Recommendation Report for Planning Permission for Works or Extension to a Dwelling

REF NO: AL/96/19/HH

LOCATION: The Old Stables
Old Dairy Lane
Norton
PO20 3AF

PROPOSAL: Proposed window to existing kitchen. This application may affect the character and appearance of the Norton Lane, Norton Conservation area.

PROPOSED NORTH
ELEVATION

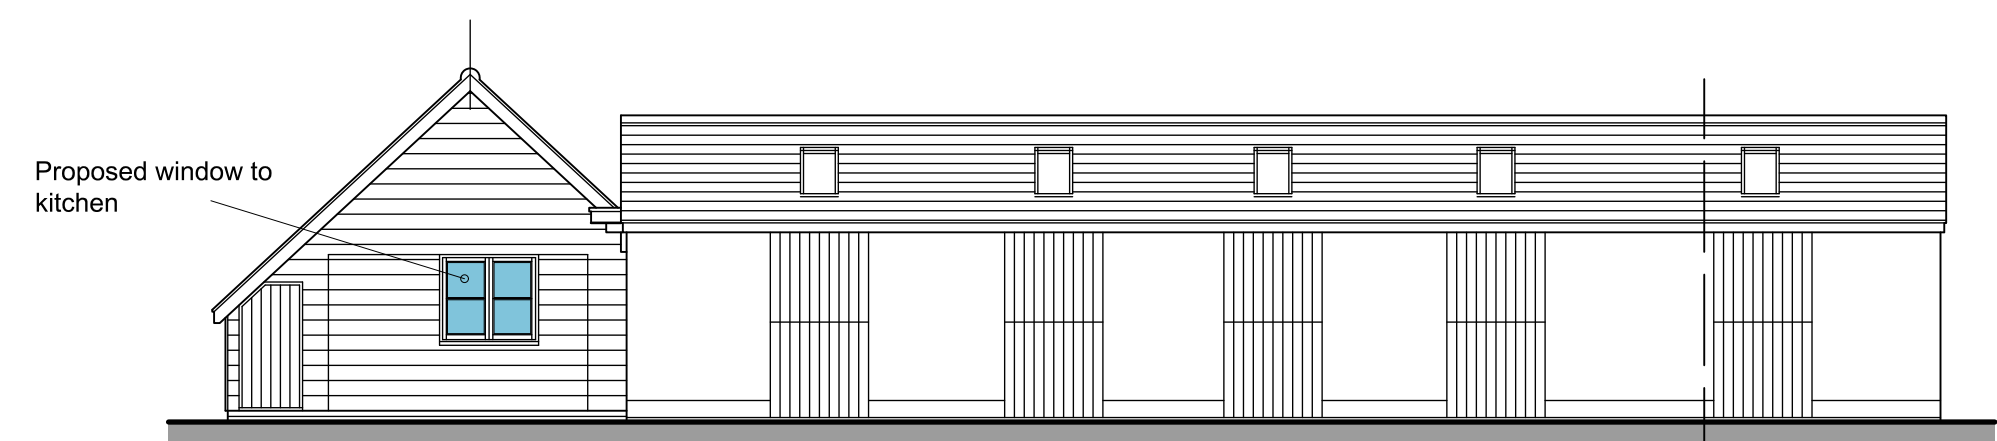
The application will install an additional window to the northern elevation of the dwelling which will serve a kitchen. The window faces the street scene however it is private road and due to the siting of the dwelling, views are minimal with around 30m retained to the front boundary.

The window will be of materials to match that of the existing and as such it appears sympathetic in appearance to the host dwelling. The additional window is not deemed to result in an adverse appearance on the dwelling or wider area and accords with D DM1 and D DM4 of the Arun Local Plan.

The dwelling is located on the boundary of the Norton Conservation Area. Para 190 of the NPPF requires the LPA to consider the significance of the impact on the heritage asset. The proposal is small in nature and reflective of the existing windows. It is considered to have a neutral impact upon the character of the building and Conservation Area and therefore accords with HER DM3 of the Arun Local Plan.

The window is modest with a width and depth of 1.2m. Due to its siting set back from neighbouring properties, it is not deemed to give rise to adverse overlooking.

Reason: For the avoidance of doubt and in the interests of amenity and the environment in accordance with policy D DM1 of the Arun Local Plan.
- 3 The materials and finishes of the external window hereby permitted shall match in colour and texture to those of the existing windows.
